# CITY OF ALBUQUERQUE

November 9, 2012

**Re: Yale Courtyards, 218 Yale Boulevard SE, Traffic Circulation Layout  
Architect's Stamp dated 11-01-12 (K16-D081)**

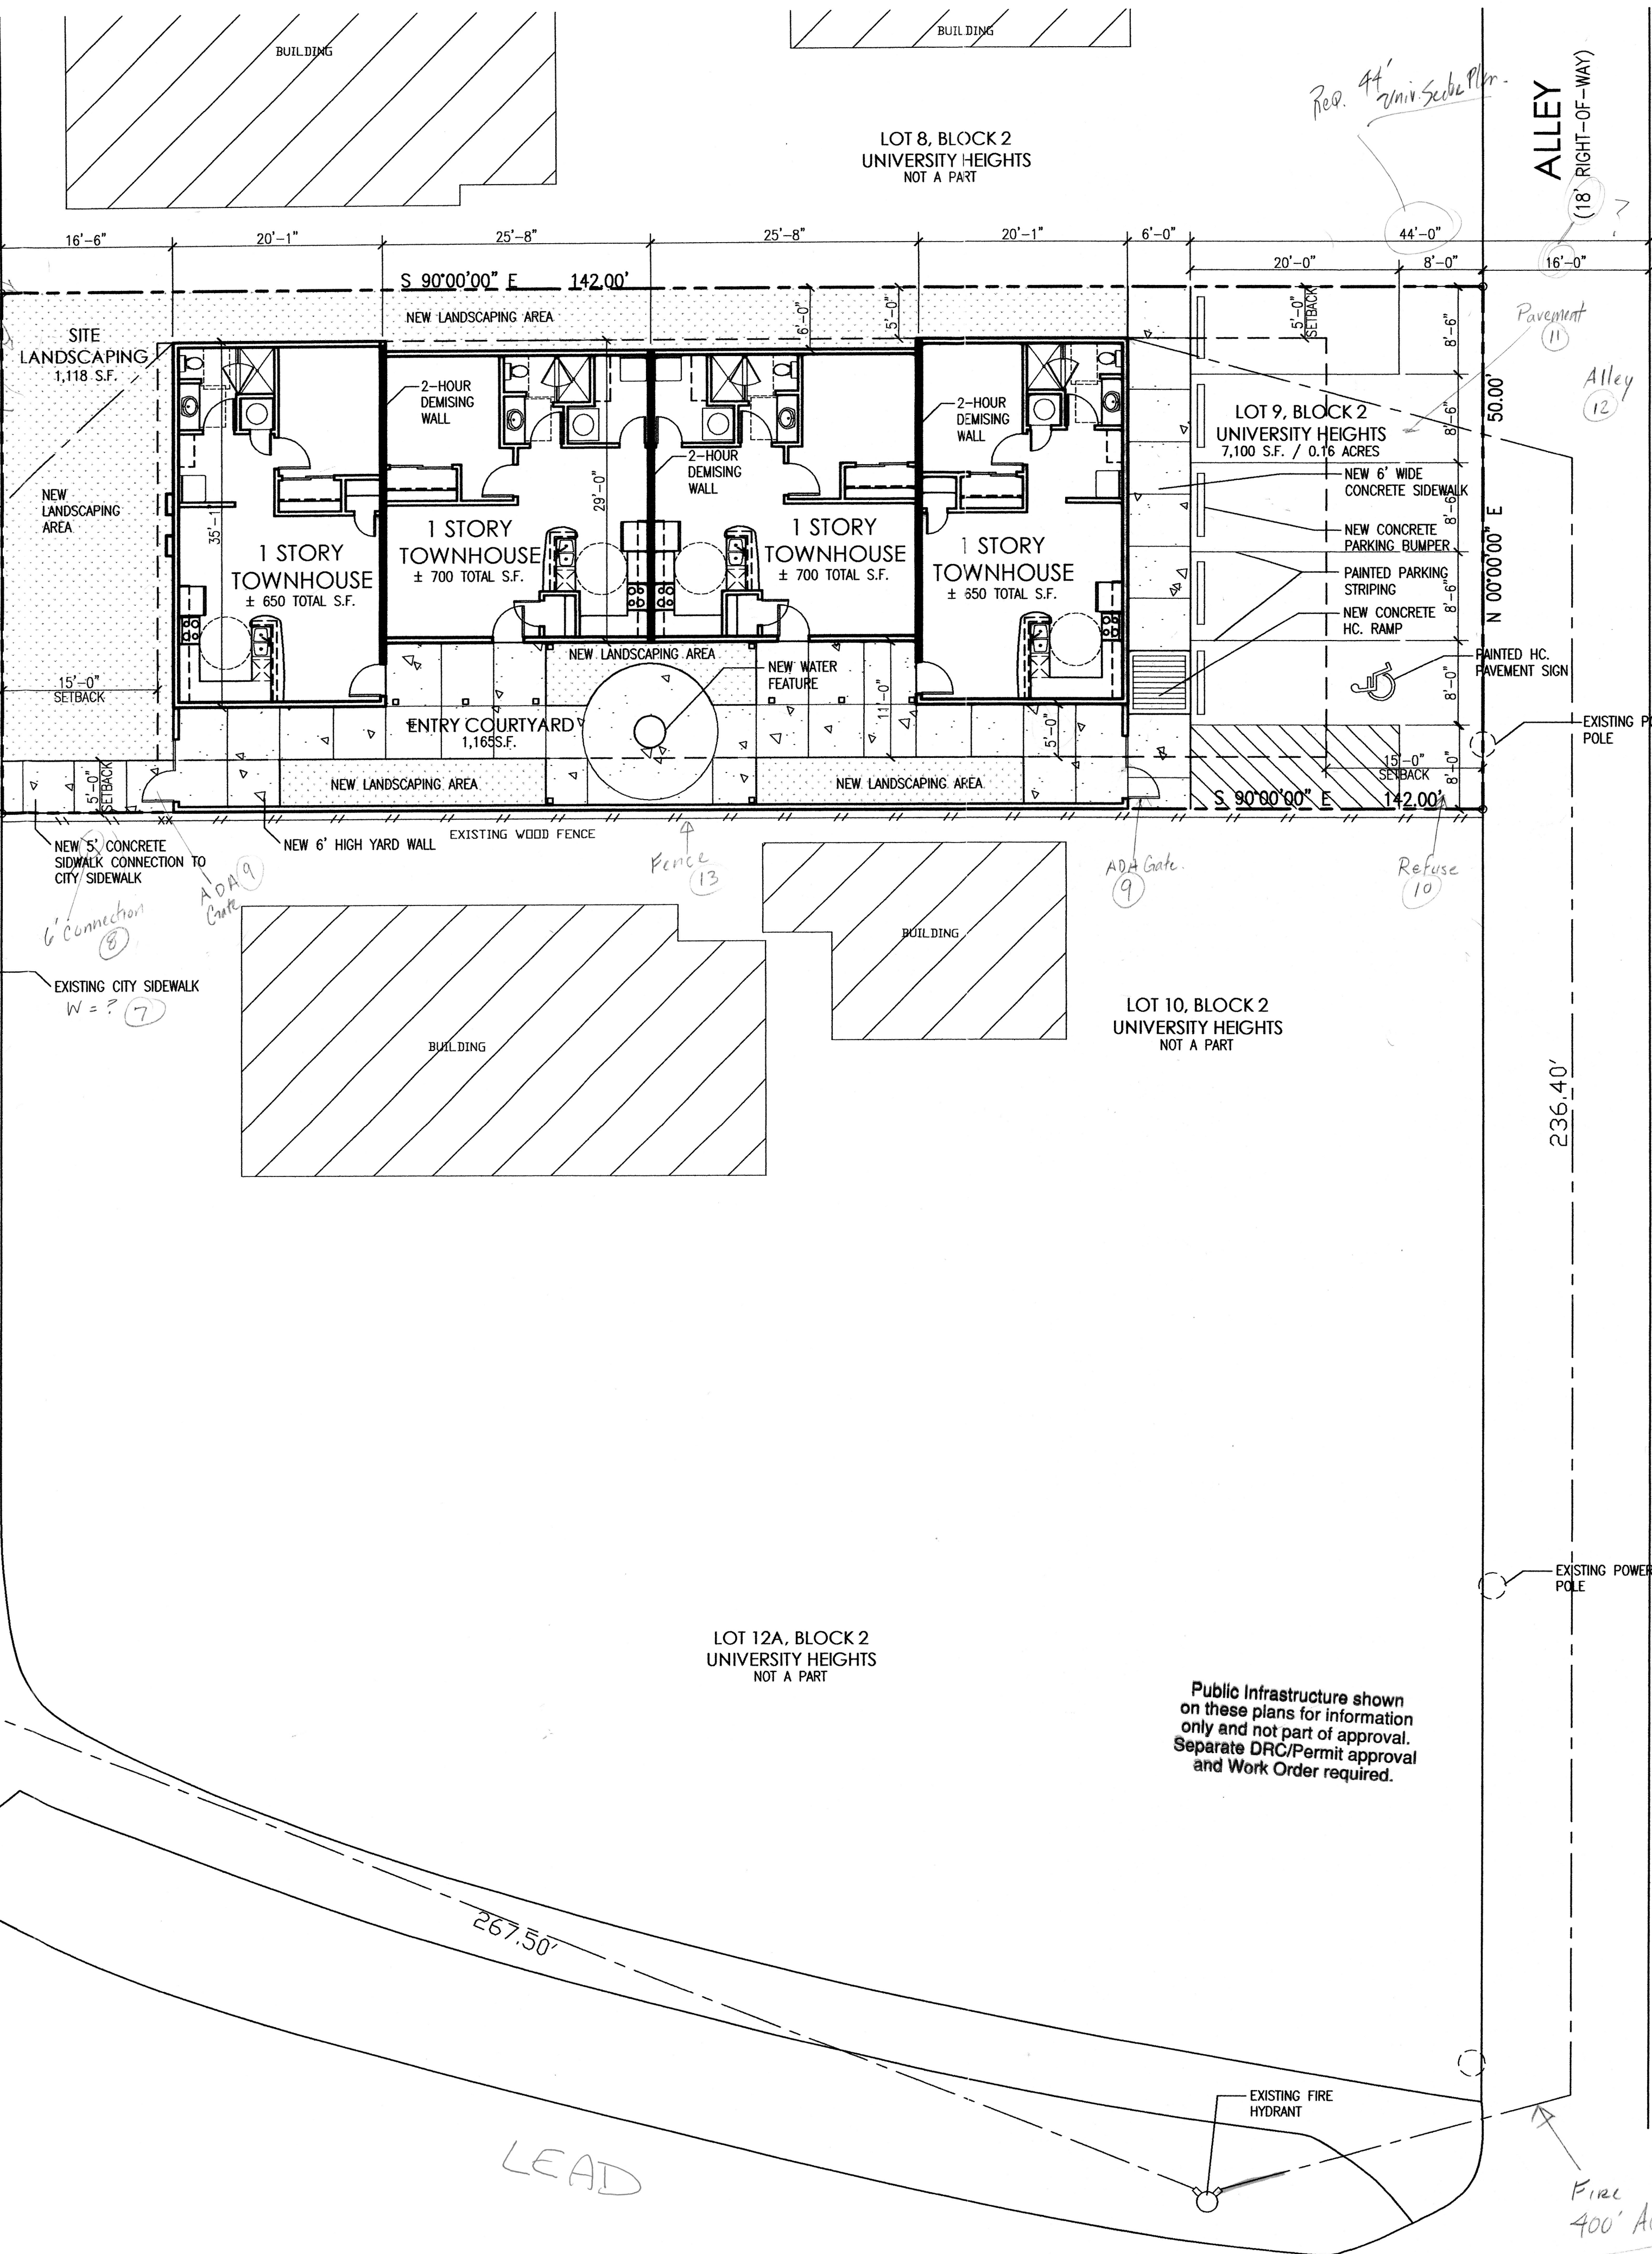
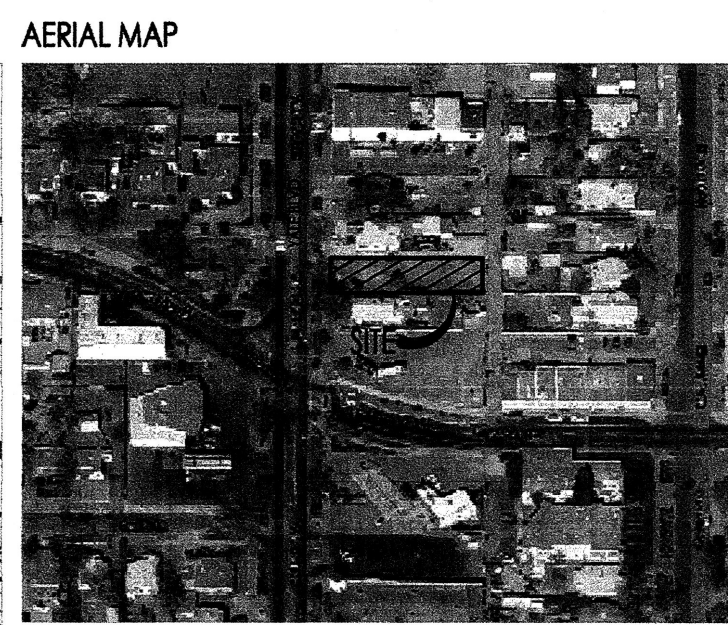
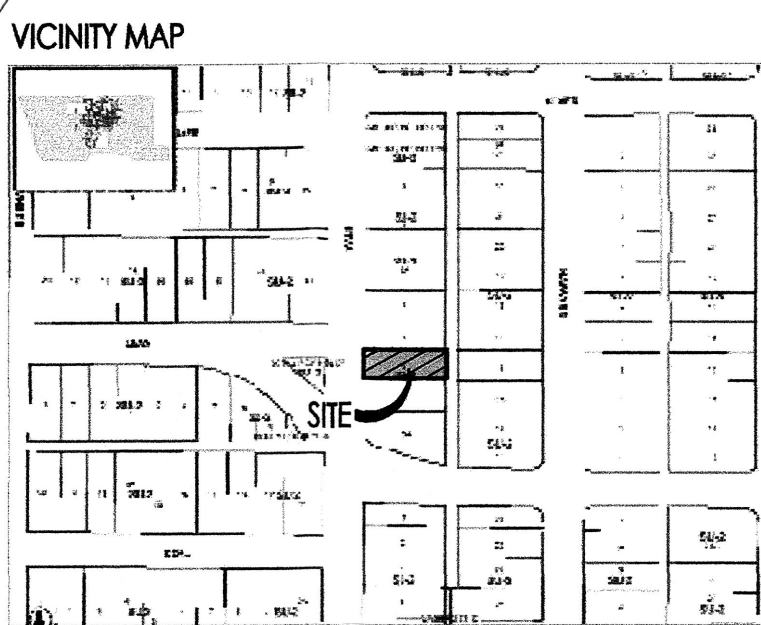
1. Please show the location of the nearest driveway on the adjacent lot. Based on a recent site visit, the adjacent property to the north shares a common driveway with this site accessing Yale. The adjacent lot also appears to have parking crossing over lot lines into the proposed site. Please clarify. Are there any existing cross access agreements?

2. List the width of the existing driveways.
3. The TCL proposes to remove the existing curb cut on Yale and replace with landscaping. Per the *Development Process Manual (DPM)*, Chapter 23, Section 6, Part B.17, "Any driveways that are abandoned must be replaced with sidewalk, curb and gutter by the property owner." Please revise your build notes accordingly (example: "Remove existing curb cut, replace with sidewalk and standard curb and gutter per CoA Standards 2415 and 2430").

4. Please place the proposed sidewalk at the property line, not the back of curb.
5. Remove the fire line; it is similar to the property line and may cause confusion.

6. Please refer to all applicable city standards.
7. Define width of the existing sidewalk.
8. The pedestrian gates must be a minimum of 3 feet in width.

9. Please show refuse location and provide COA Solid Waste approval, contact Lee Whistle (924-3631) from Solid Waste.
10. Define the surface material area of the parking area. Please note that the *Development Process Manual* requires a minimum of 2 inches of asphaltic concrete or equal.

11. Label Lead on the TCL.
12. Clearly show the limits of all fencing. Verify that the fencing will not interfere with clear sight.

13. A 6-foot wide, ADA accessible, pedestrian pathway is required from the ADA parking to the building.
14. Is the existing alley paved? If the alley is not paved, it must be paved at this time. A separate work order will be required for the alley pavement.
15. A 6-foot wide, ADA accessible, pedestrian pathway is required from the roadway to the building.
